Date: 5 November 2025

BEACON FEN ENERGY PARK

PROPOSED BEACON FEN ENERGY PARK (APPLICATION REFERENCE: EN010151) NOTIFICATION OF PROPOSED CHANGE TO THE DCO APPLICATION

© Copyright Reserved  
N:\ST19595-SOLAR PV\DCO BECKER FEN\03-DESIGN\AUTOCAD\ST19595-461-VEGETATION REMOVAL PLAN REV BECKER FEN SUBSTATION UPDATED.DWG

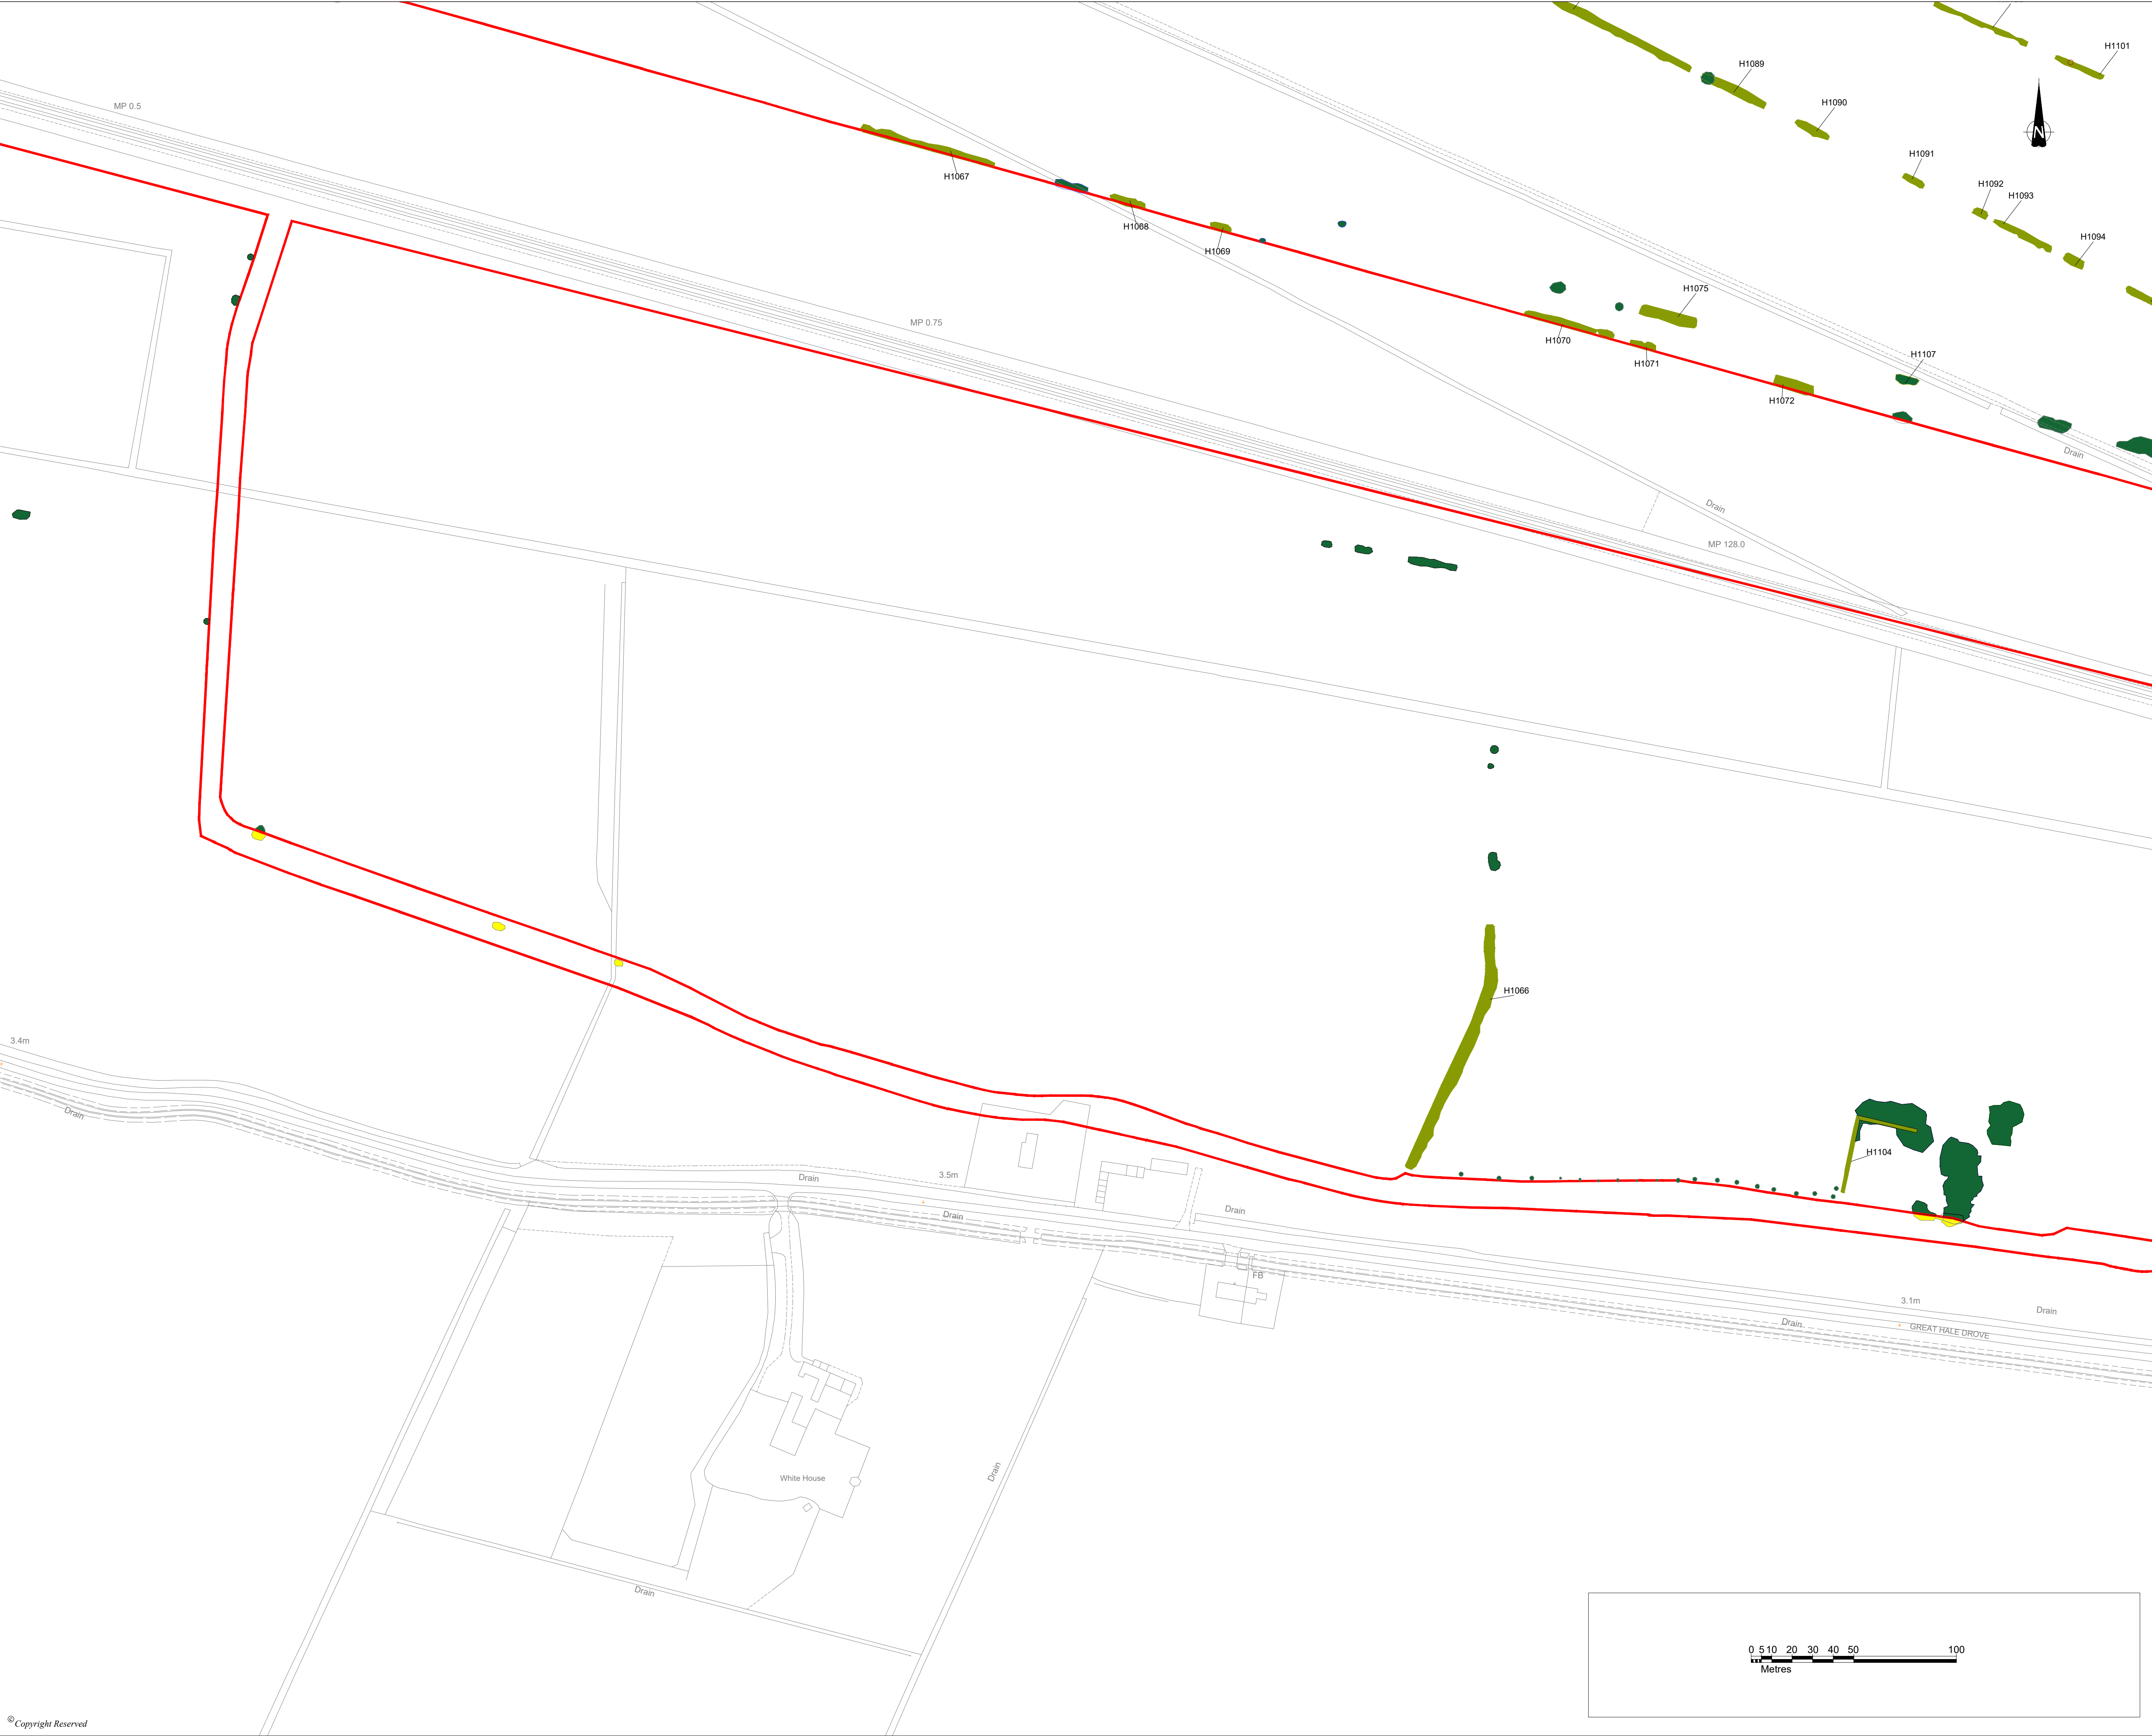
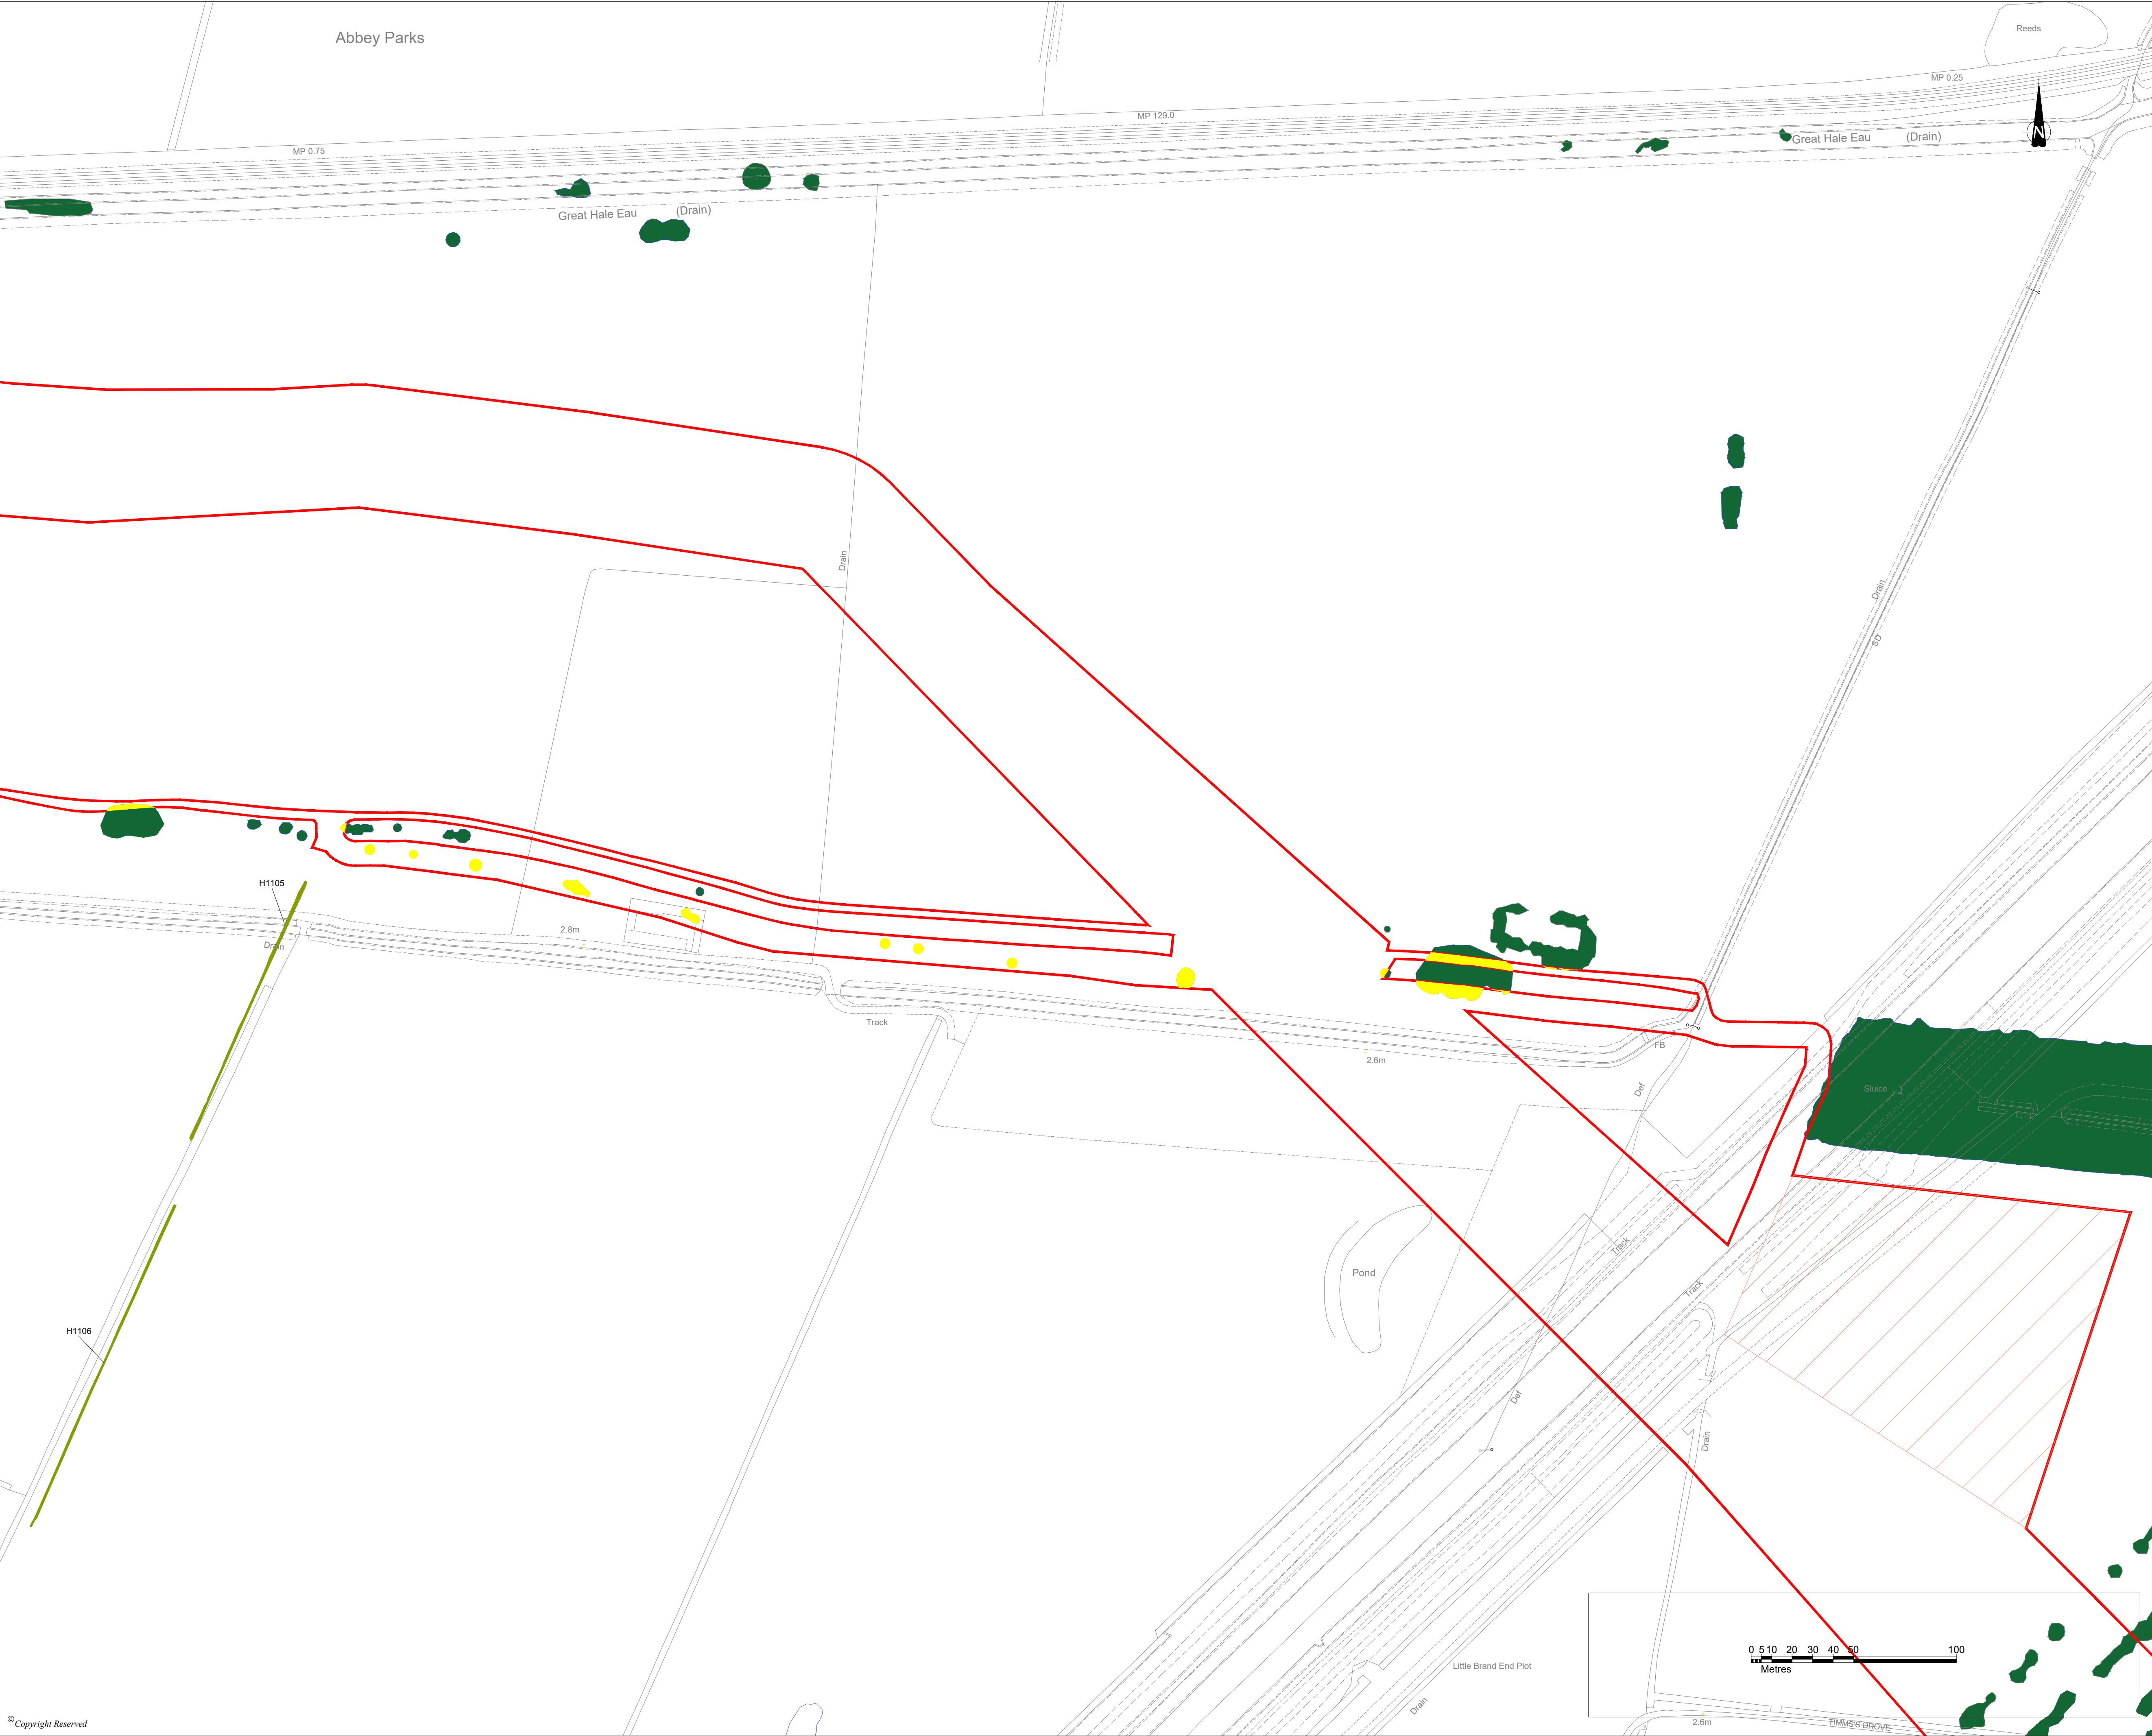
- Extension of the temporary laydown (Work No. 5D) to an area that is largely existing hardstanding adjacent to the south; and
- Vegetation removal and infilling of the existing drainage pond adjacent the Substation to construct the Substation extension works (Work No. 5E);
